WISWELL PARISH COUNCIL

Planning Application No: 3/2011/0634

**External alterations to 2 elevations, including porch extension, new roof lights, additional windows and replacement of gothic windows
36 Pendleton Road, Wiswell, Clitheroe, BB7 9DD**

Description	By
PROPOSED ELEVATIONS	SEV

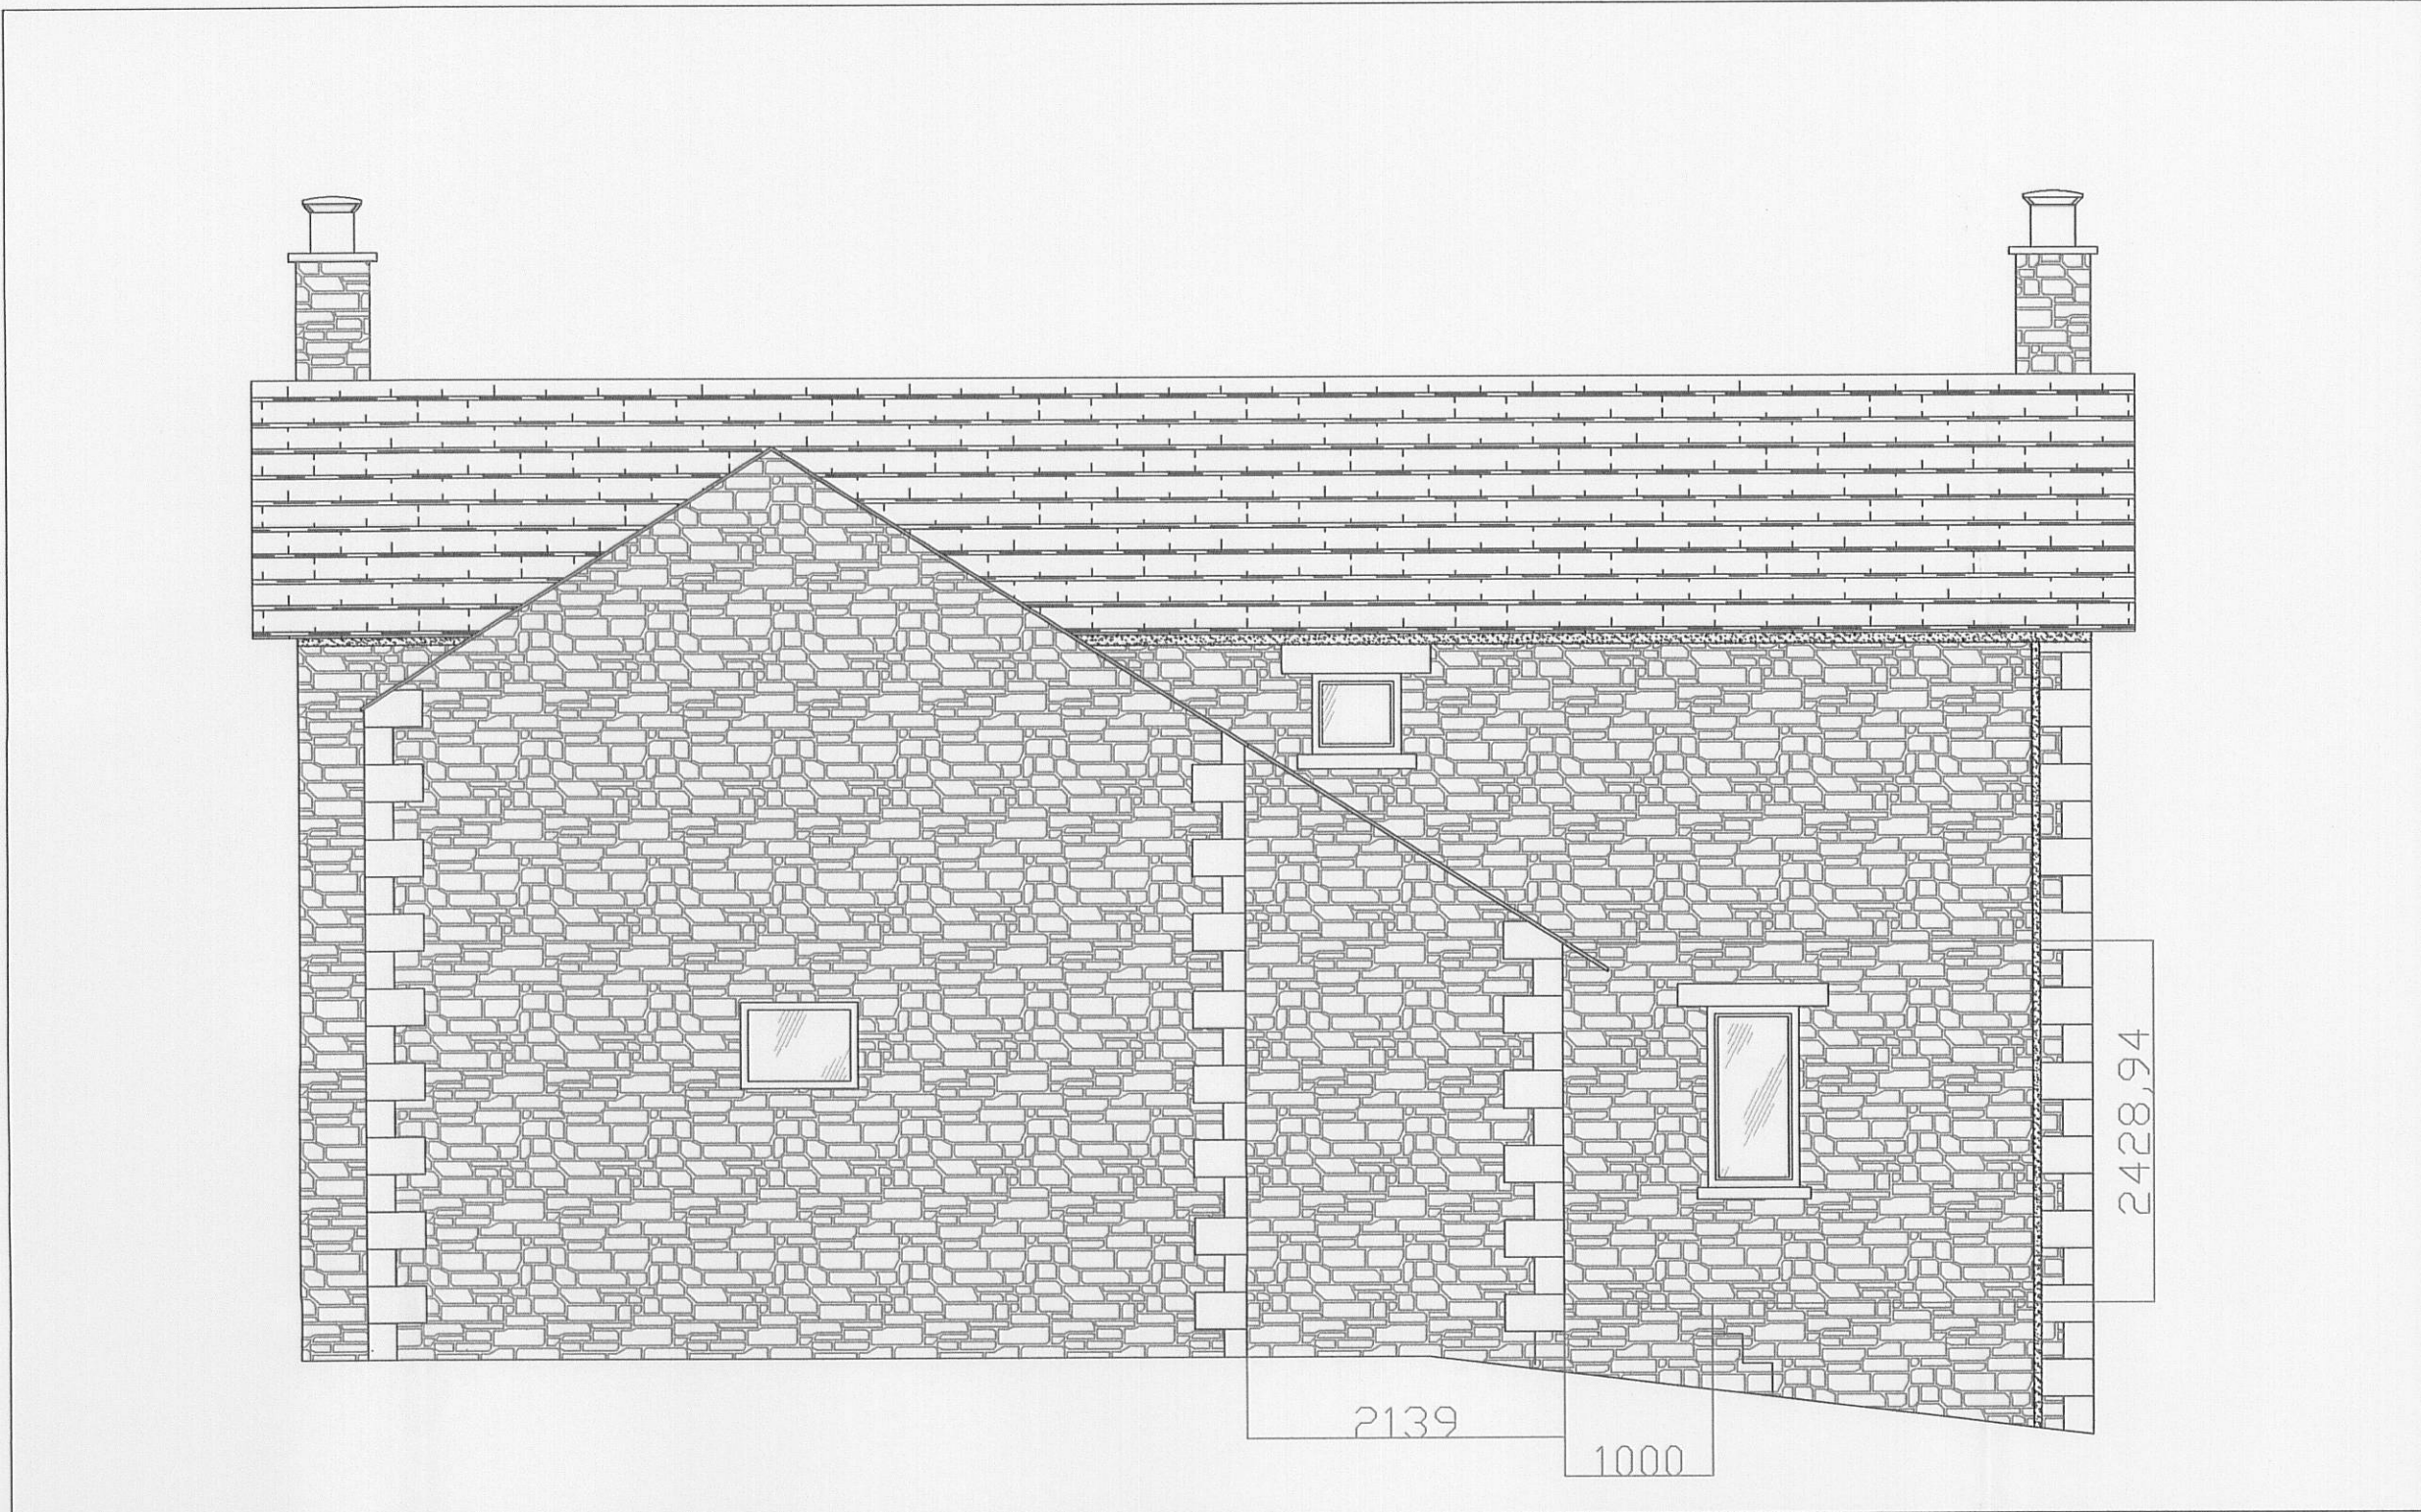
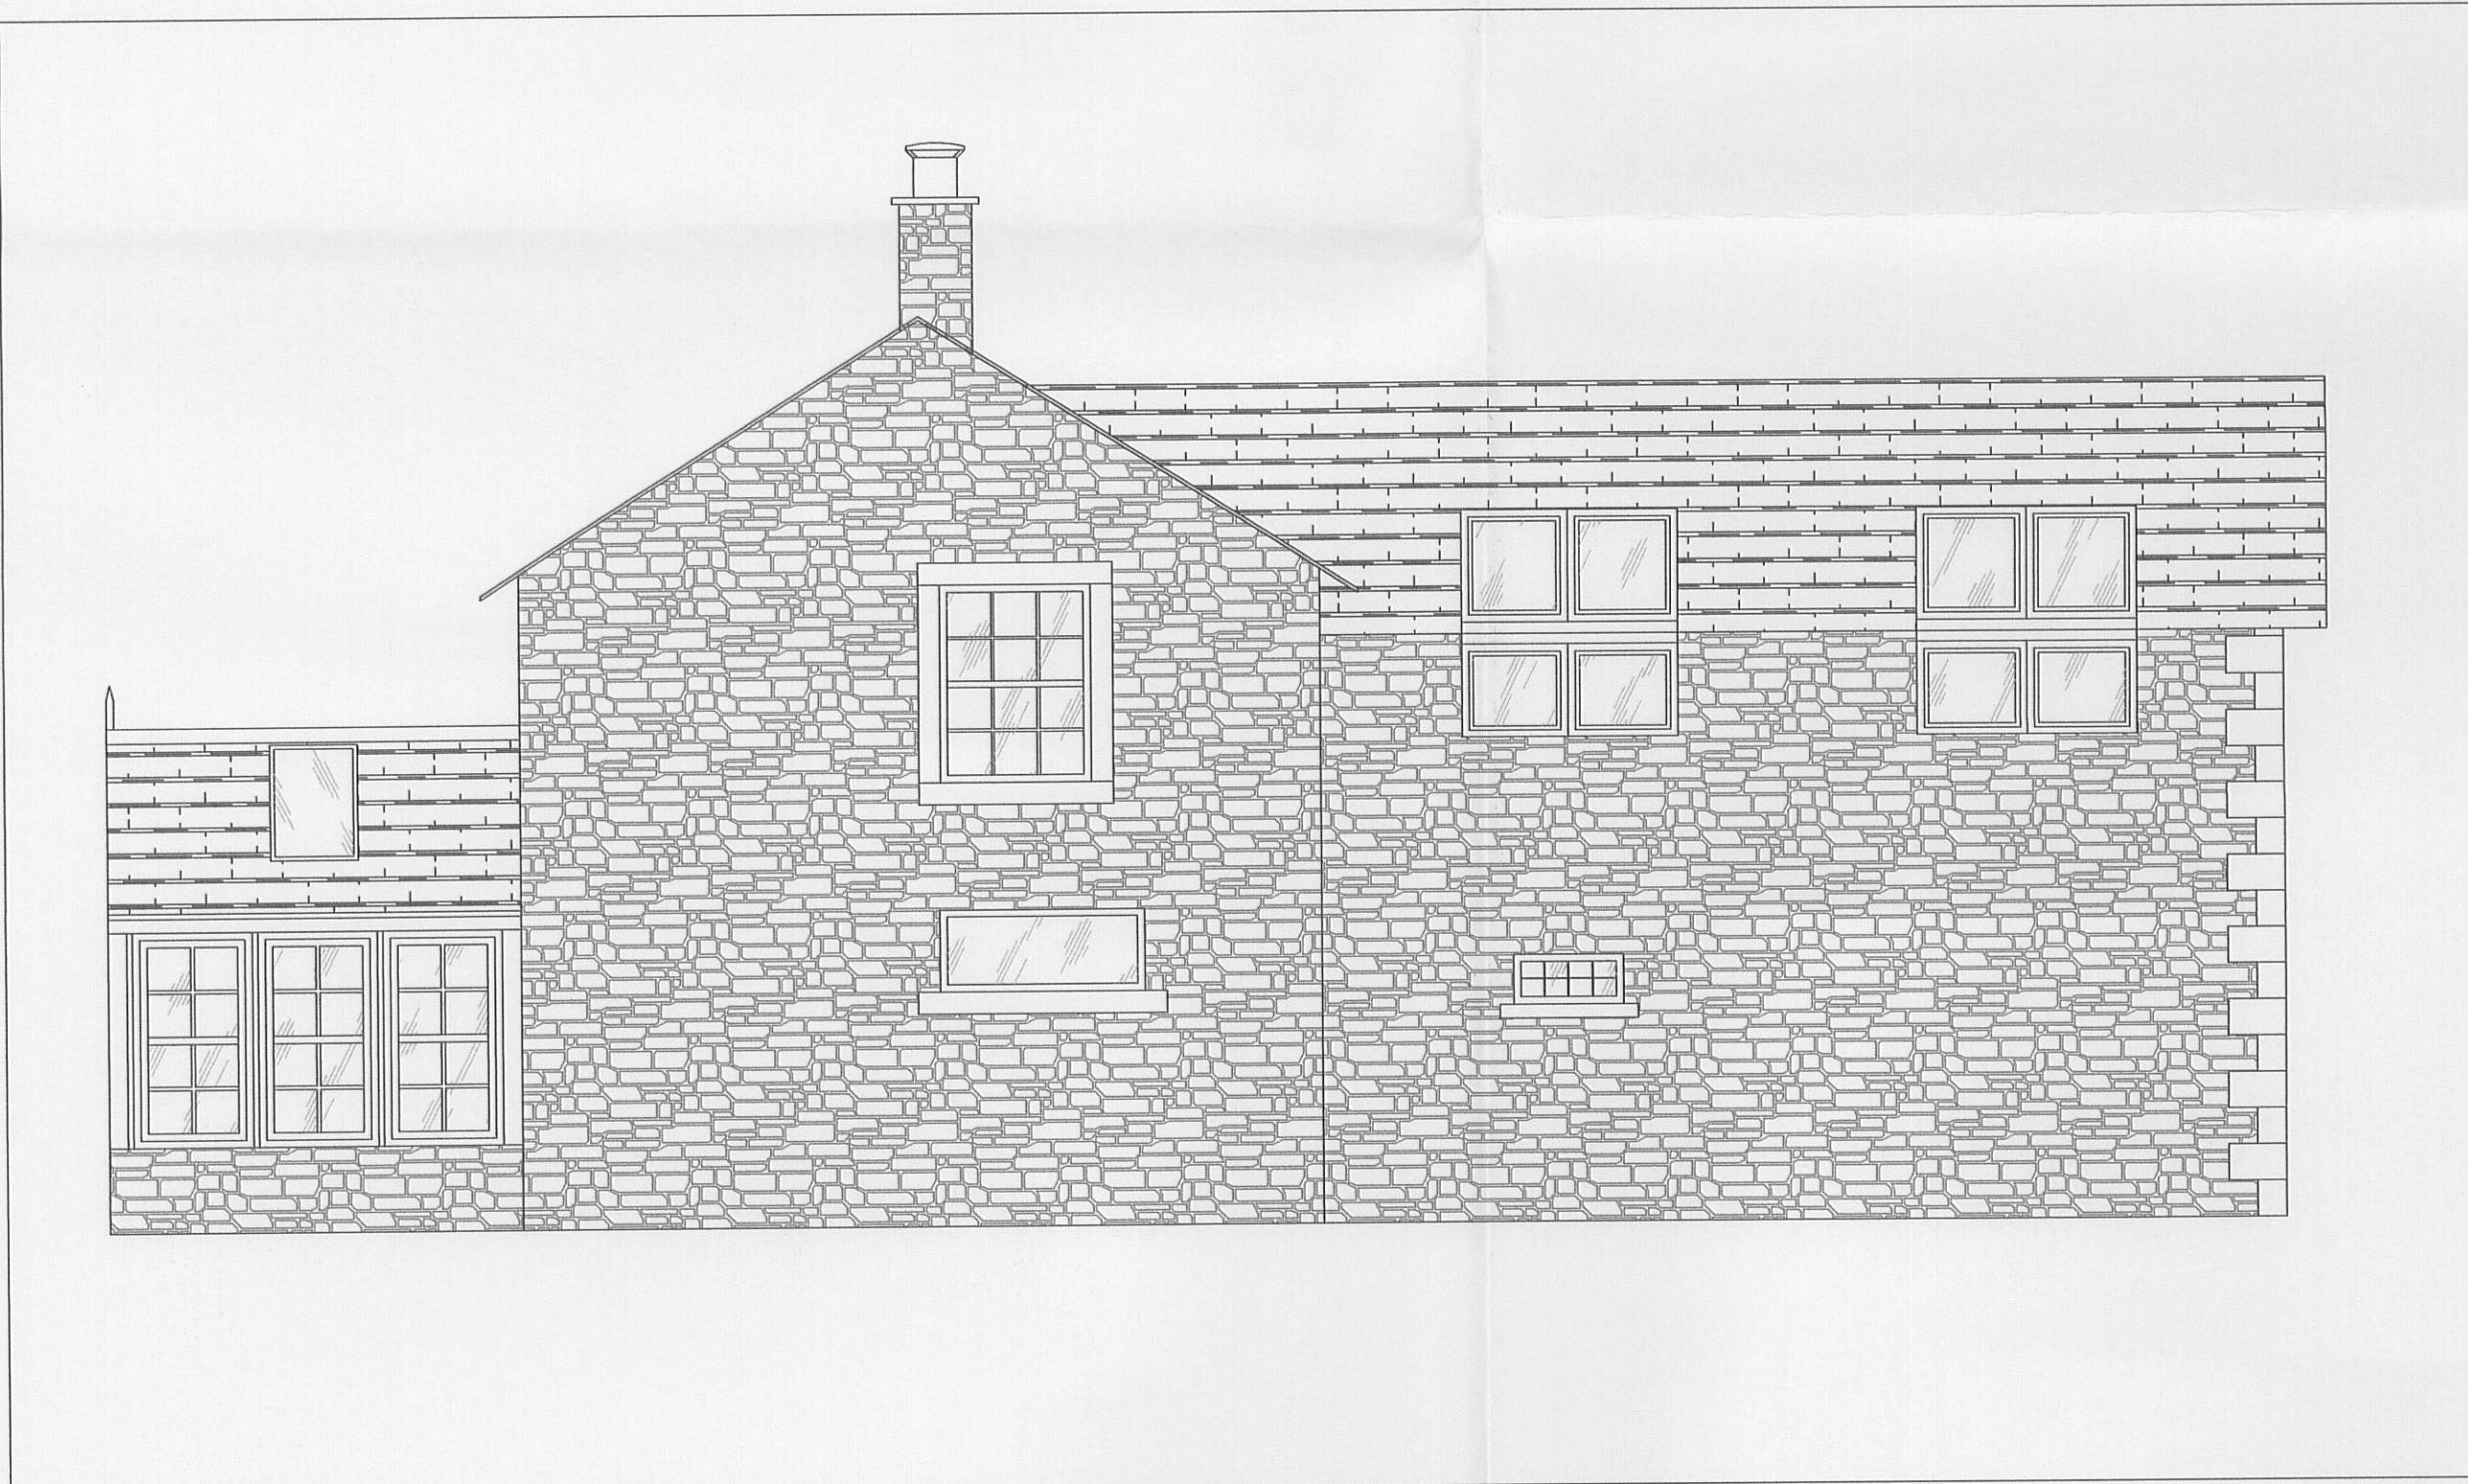
The above application has now been considered by members of the Parish Council. The Councillors believe that the proposed changes to the property are not in keeping with other cottages in the village, will dominate the original cottage and overshadow the property on the opposite side of the road. They therefore wish to object to the plans and make the following observations:

1. The gothic windows are more in keeping with the village than the proposed replacement square ones.
2. The proposed changes to the roof details, overhanging the roof at the gable ends, are not a cottage feature in the village or the Ribble Valley.
3. The catslide roof of the proposed porch extension is not a cottage feature and will be detrimental to the street scene in the conservation area.
4. The proposed roof light in the porch would have a detrimental effect upon the privacy of the property on the opposite side of the road.
5. Moving the wall forward above the garage will detract from the cottage look of the property and make the original extension the dominant part of the property.
